OUT18/8355

**Orange Grove Solar Farm (SSD 8882)
Comment on the Environmental Impact Statement**

Alison Collaros
A/Manager Assessment Advice
28 June 2018

Figure 2 Site Layout, Locality and Drainage Features

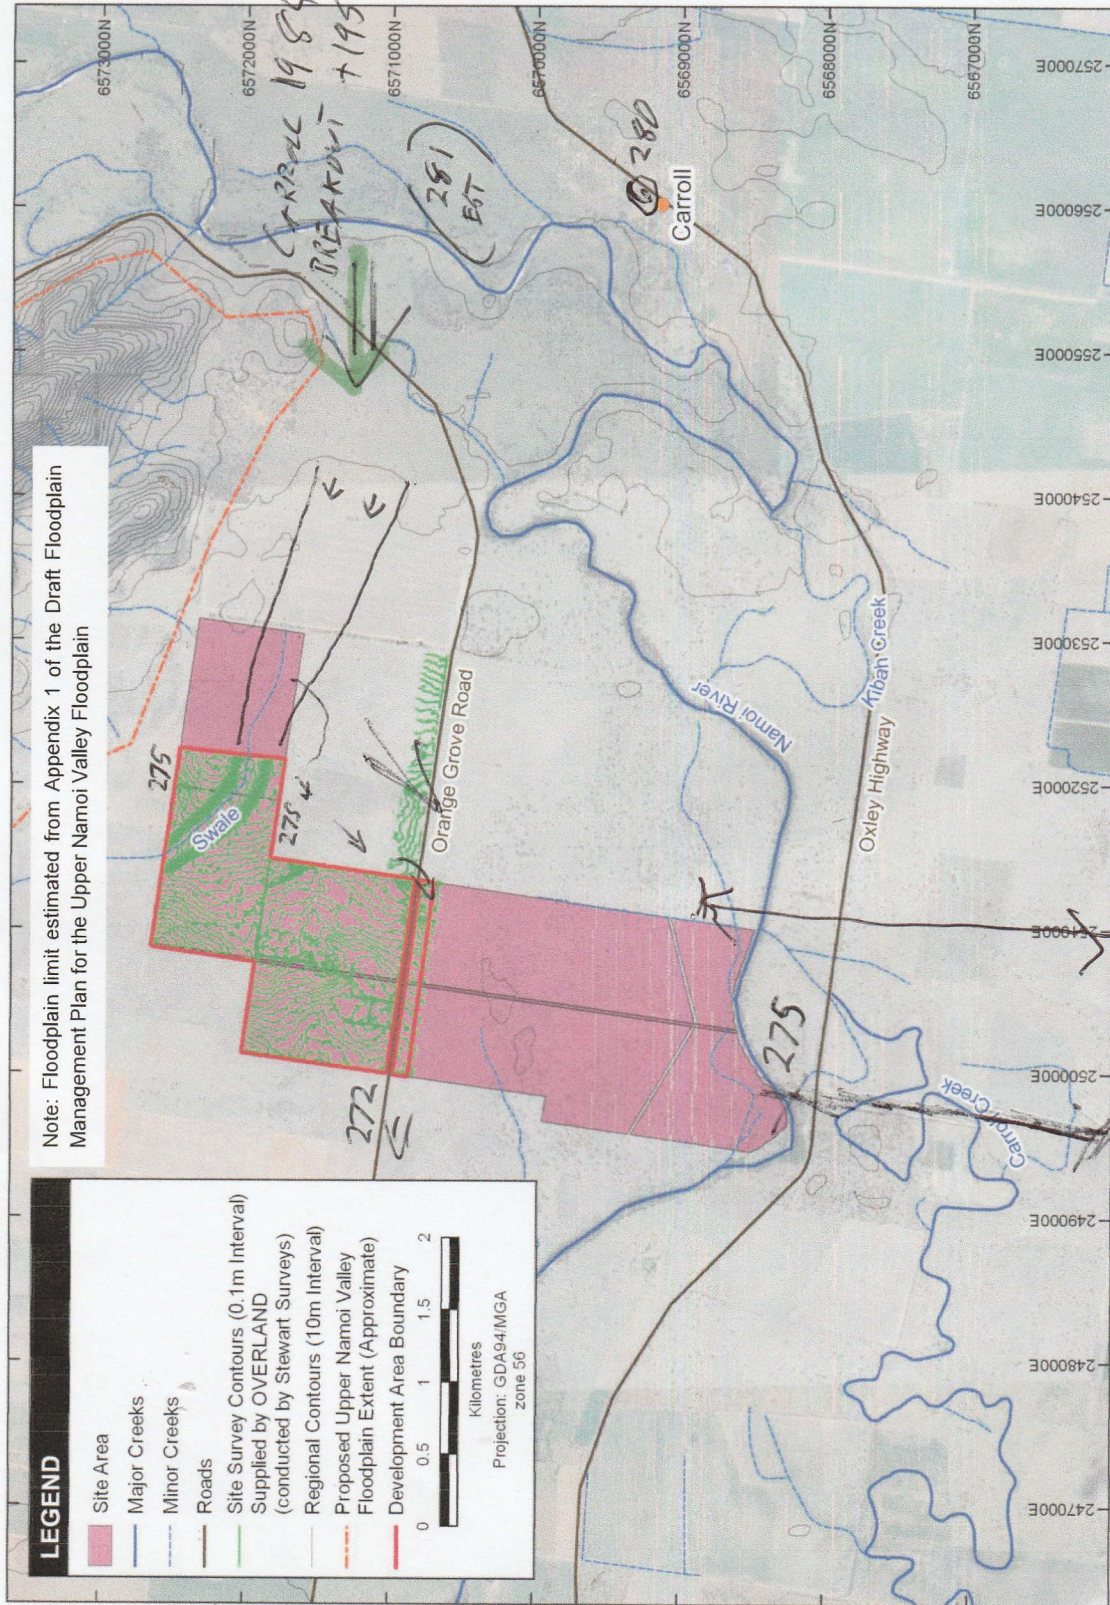
- It is recommended additional flood assessment be completed to determine whether the existing 1st order watercourse located within the development footprint is a breakout channel of the Namoi River for the large design flood in the draft Floodplain Management Plan for the Upper Namoi Valley Floodplain (FMP). If this is the case an assessment against the requirements of the FMP will be required.

- The EIS indicates that using the highest historical flood level monitoring, the modelled level of the nearby Namoi River (272.3 m) would not reach the lowest surveyed level of the development (272.5 m). However the assessment also indicates that a mapped 1st order watercourse may be a breakout channel for the Namoi River that has flowed in the relevant large design flood. Additional flood assessment is recommended to confirm this and hence to determine its relevance under the Draft Floodplain Management Plan for the Upper Namoi Valley Floodplain.

- Whether the mapped 1st order watercourse is a breakout channel from the Namoi River or is limited to conveying local runoff, the ability to ensure this function continues is important. Managing the potential for erosion and sedimentation during construction and operation would also be required.

- The proponent has indicated that there is a small farm dam that will be removed as part of site establishment activities. There has been no assessment of the impact of removing the dam, including dewatering and removal of aquatic habitat. Rehabilitation will be needed to ensure adequate reconstruction and stabilisation of the existing drainage channel.
